# **AQUIND INTERCONNECTOR**

## **Environmental Statement – Volume 3 – Appendix 27.1 Consultation Responses**

Document Ref: 6.3.27.1

**DATE: 14 NOVEMBER 2019**

Figure 15.49: Indicative Landscape Mitigation Plan Option B(1) (south)

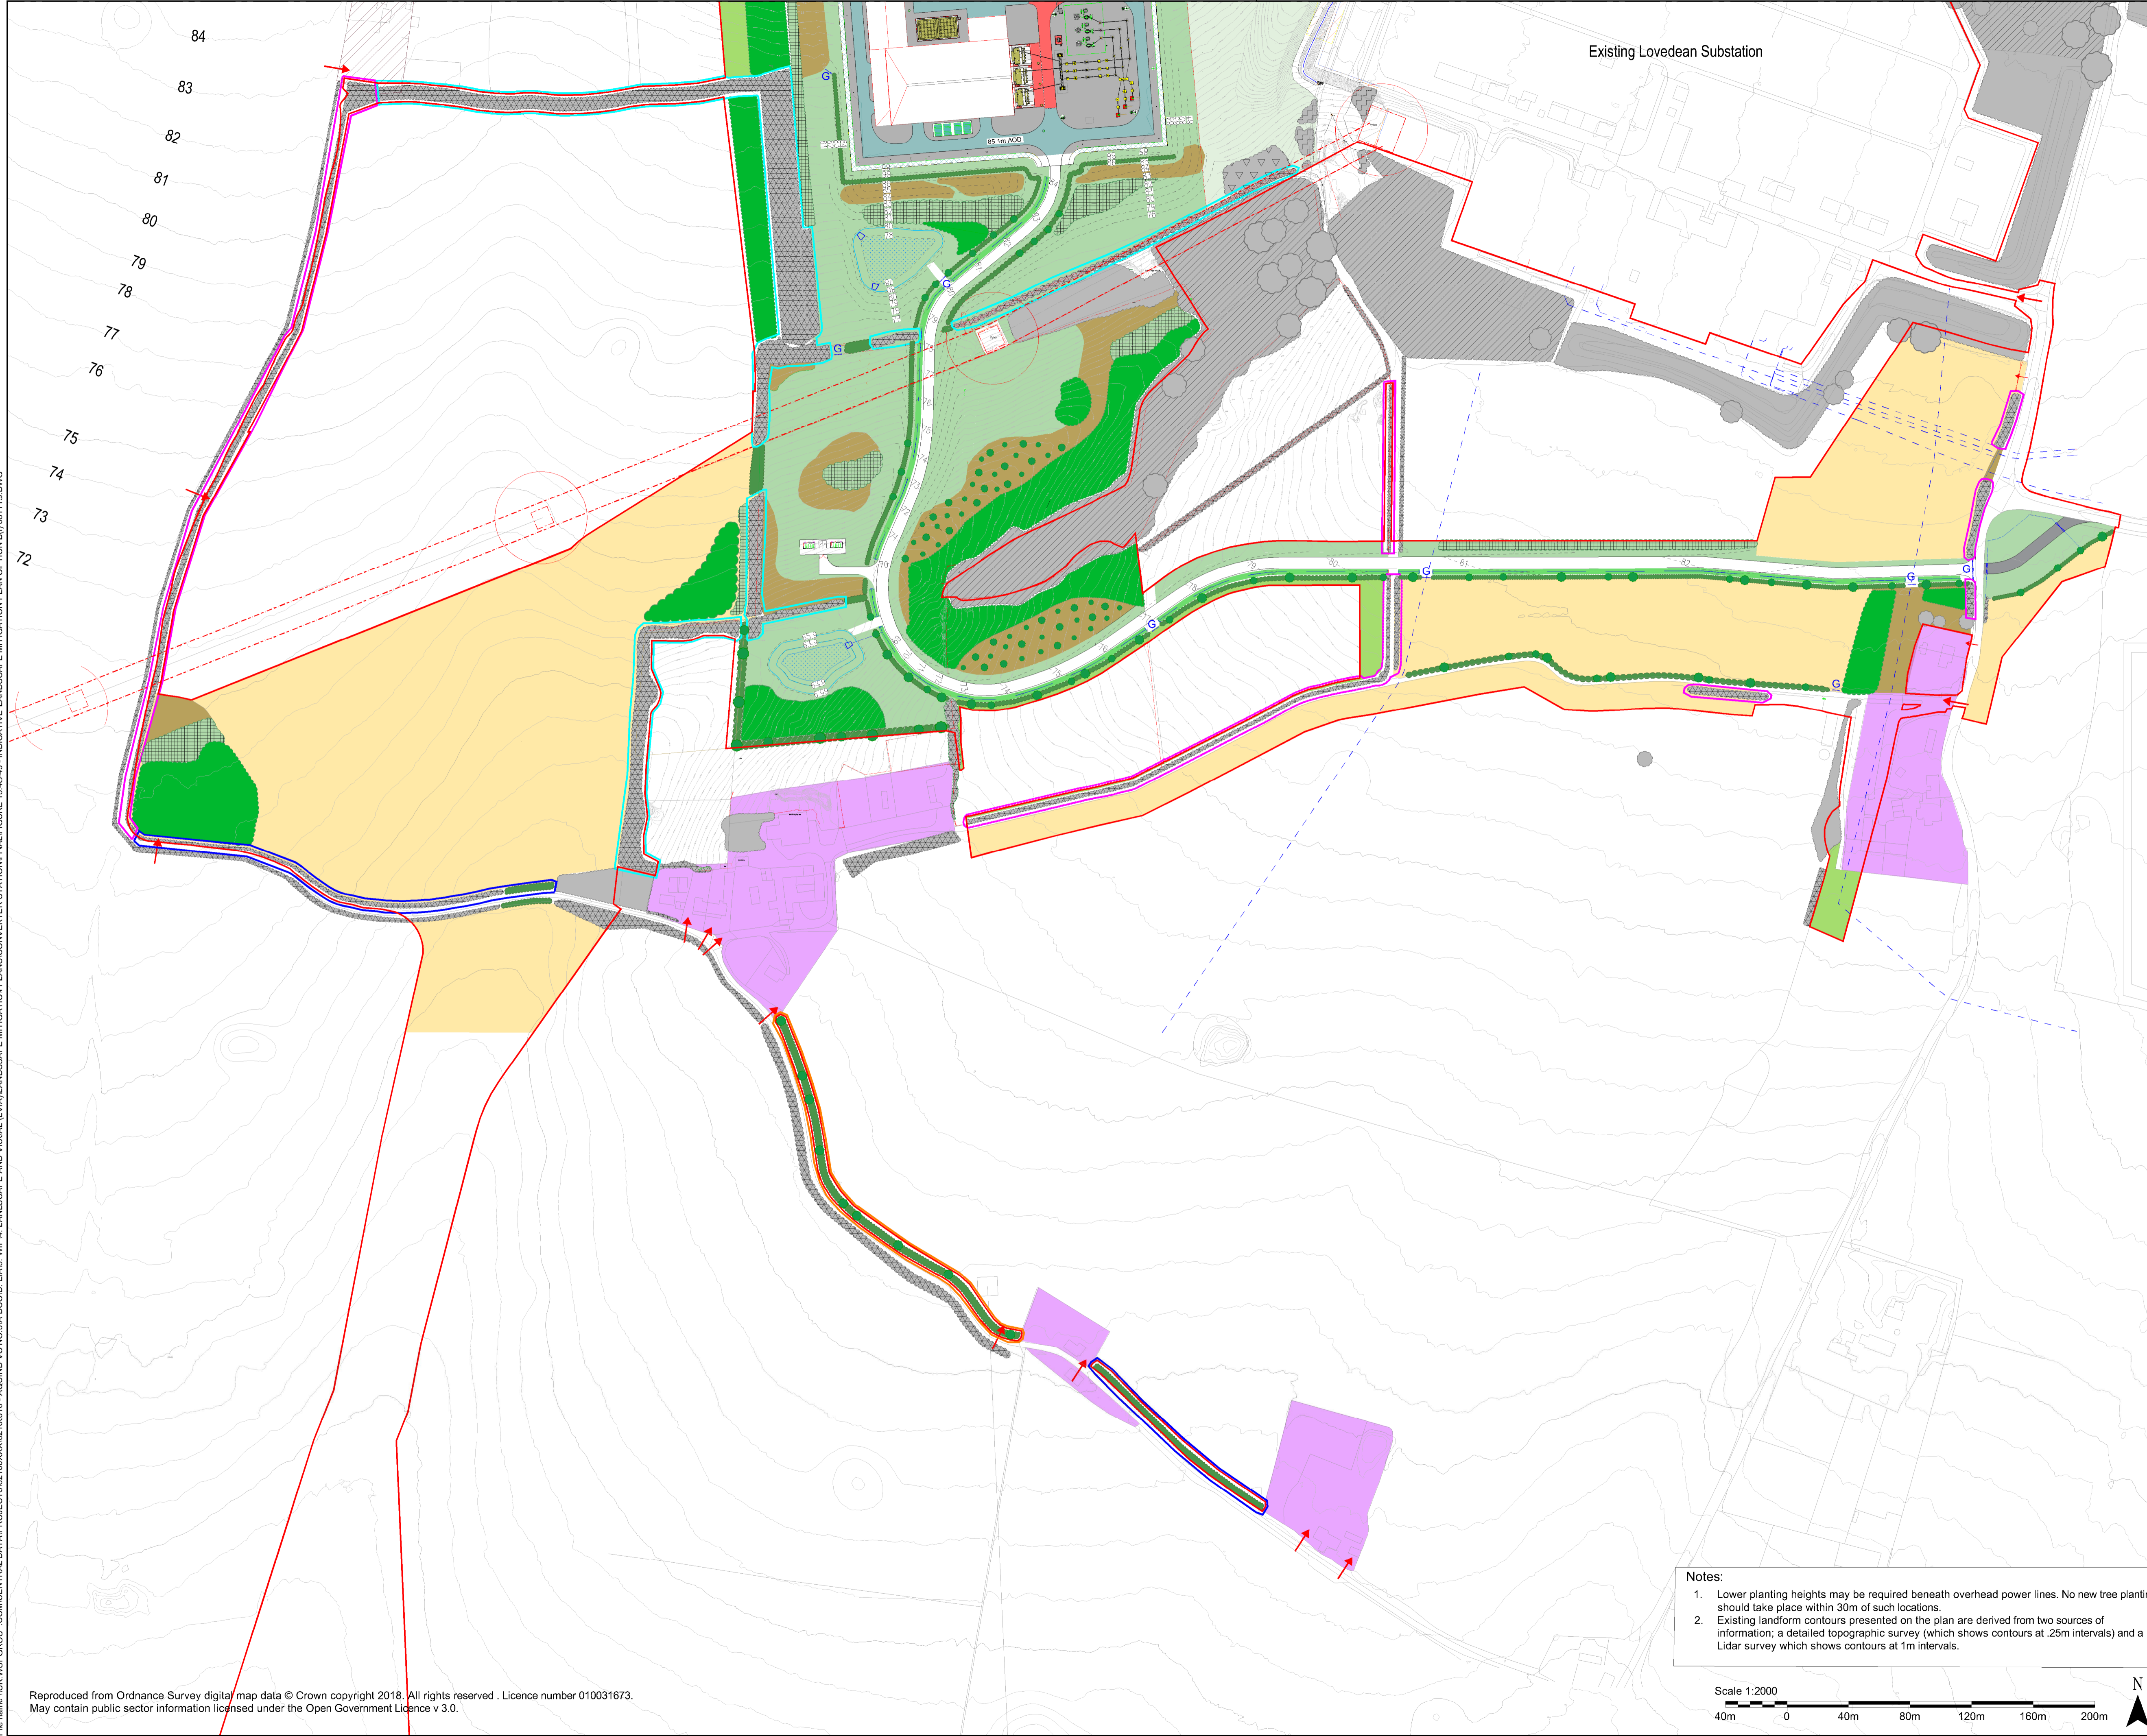
Consultee	Date (Method of Consultation)	Discussion	Summary of Outcome of Discussion
<b>SDNP</b>	26 April 2019 (via email)	Section 8: 8.1 There is concern about the frequent referral to the use of the excavated material for landscaping bunds. The use of bunds will be totally out of character with the area and will do nothing to mitigate the impact of the proposed development other than to create further manmade features in the landscape. Instead it is suggested that the material be spread more widely and used to sculpt more subtly the landform locally which can then be planted to create a more gently undulating landscape. However the impact of this on drainage will need to be assessed and integrated with the proposed drainage pond taking surface water from the site.	Reprofiling of landform will take place to provide some visual screening and utilise site fill resulting from excavated earthworks during the construction of the Converter Station. However, the visual impact of such reprofiling has been considered and is detailed in Chapter 15 (Landscape and Visual Amenity) of the ES Volume 1 (document reference 6.1.15).
